**MODIFICATION REQUEST:
NEWCASTLE REGIONAL MUSEUM
REDEVELOPMENT
Workshop Way, Newcastle
(MP 06_0083 MOD 2)**

Installation of security entry gates

Director-General's
Environmental Assessment Report
Section 75W of the
Environmental Planning and Assessment Act 1979

June 2012

TITLE
Elevations
North Elevation

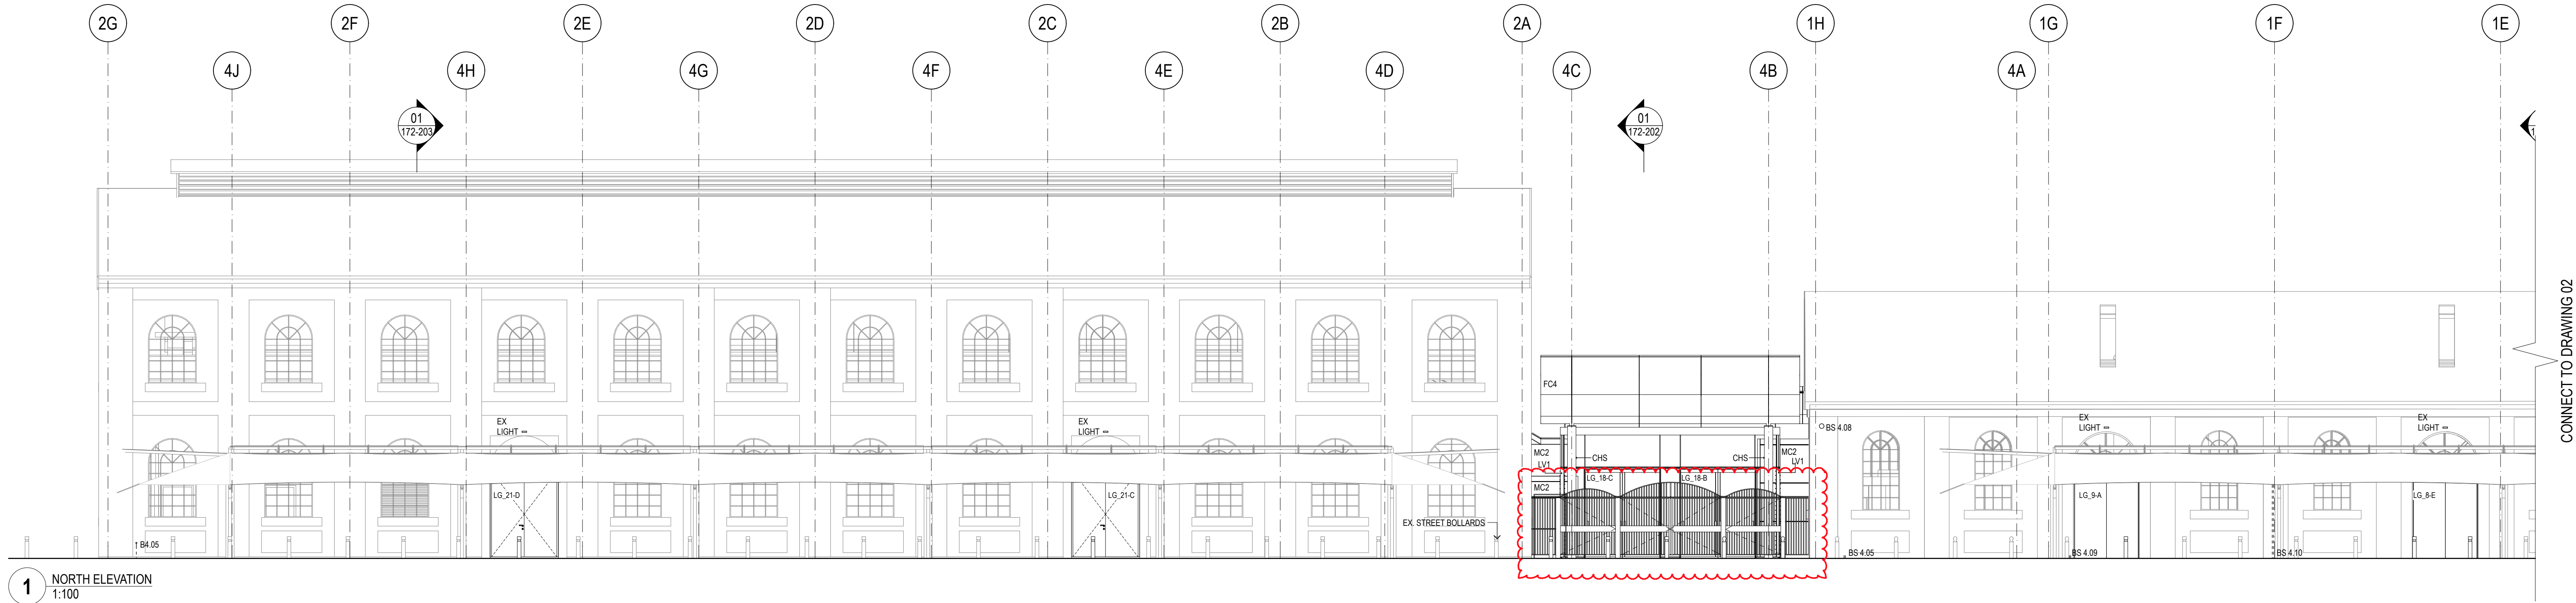
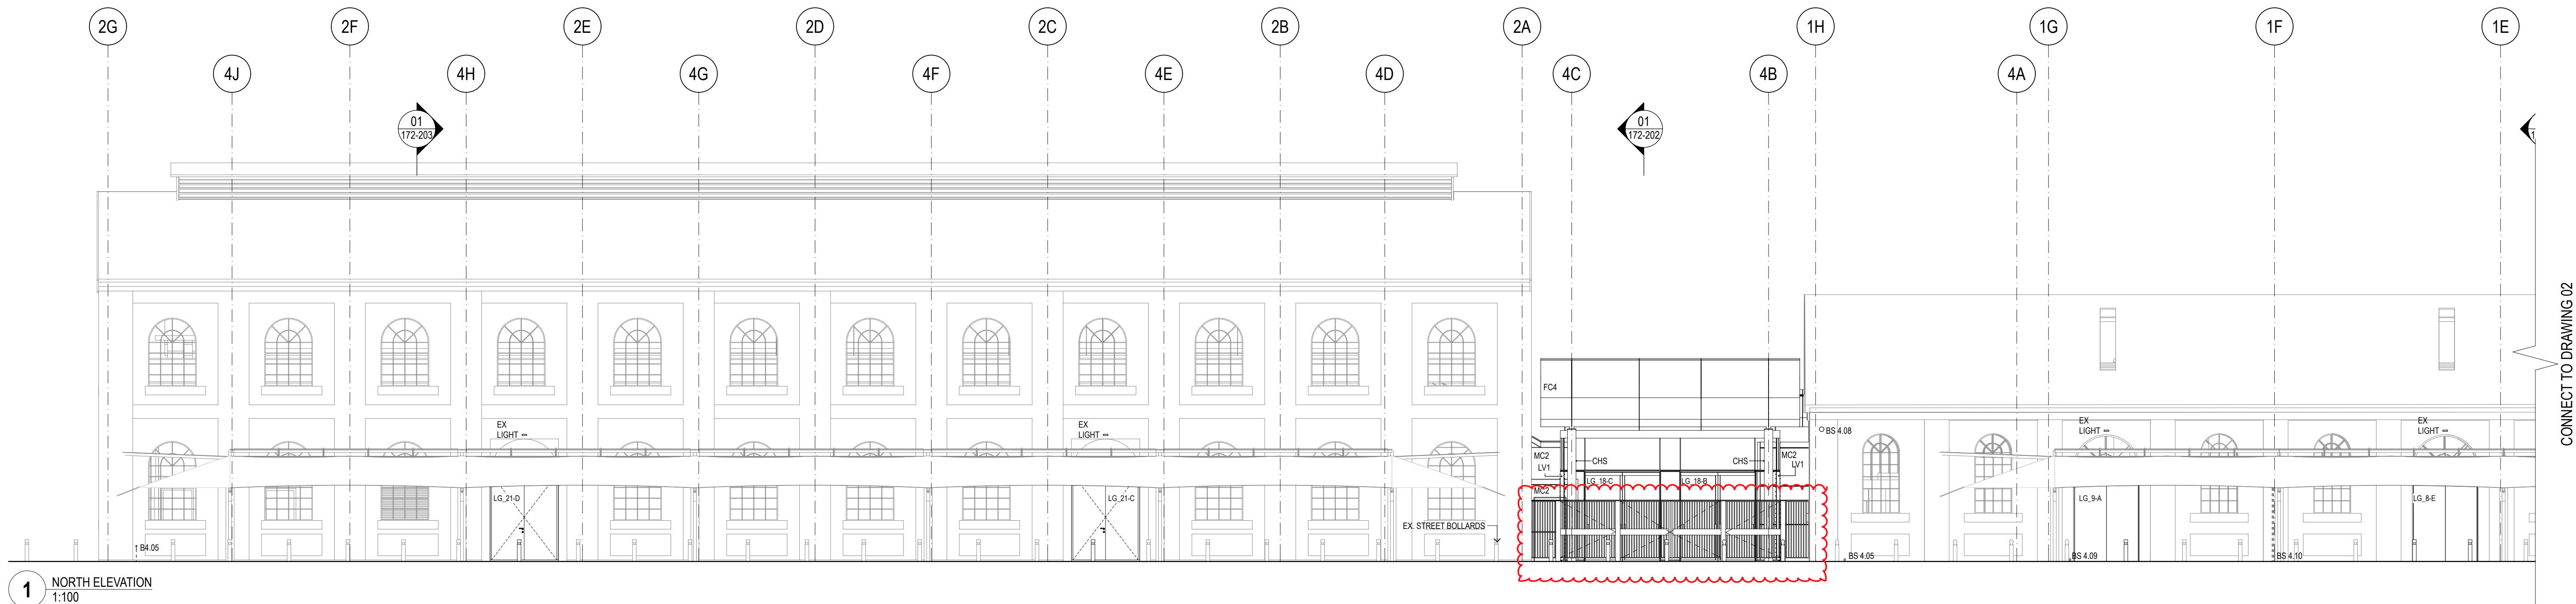
The Heritage Branch of the Office of Environment and Heritage did not support the design of the gates in their original form as the gates would have the potential to diminish the visual character of the heritage buildings and the area. The Heritage Branch requested further justification for the proposed gates as well as further consideration of alternative solution and designs, including a more modern design.

The Heritage Branch of the Office of Environment and Heritage originally requested further details regarding how the gates, as originally proposed, relate to elements of the historic buildings and the impact on the visual character of the historic buildings. The Heritage Branch also considered that a more contemporary design would be more suitable to retain the visual separation of the two buildings.

In response to the concerns raised by the Heritage Branch, the proponent provided further documentation on 21 May 2012, including an amended gate design supported by a heritage impact statement that concluded that the amended design of the gates, which provided a more modern design by removing the curved elements, would not have an impact on the significance of the heritage buildings. The revised design also provided a greater setback from the alignment of the two buildings to ensure the two buildings still visually presented as separate entities.

After further consultation with the Heritage Branch, the proponent submitted a revised design to address their concerns. The revised design removed the curved elements and provided a greater setback to ensure the visual separation of the two heritage buildings. The revised design was also supported by a heritage impact statement that considered the design was contemporary and consistent with the contemporary additions that have been undertaken for the adaptive re-use of the heritage buildings. The design would also have minimal impact to the building fabric, with any impacts considered reversible. The revised design was considered satisfactory by the Heritage Branch.

The department considers the proposed gates acceptable as they would have minimal heritage impacts on the buildings and as the visual separation of the two buildings can be maintained through the contemporary and transparent design of the gates. Furthermore, the department has included a recommended condition that requires the security gates be setback a minimum of 500mm from the face of the northern wall of the Blacksmiths Shop building to ensure that the visual separation of the two buildings is maintained.
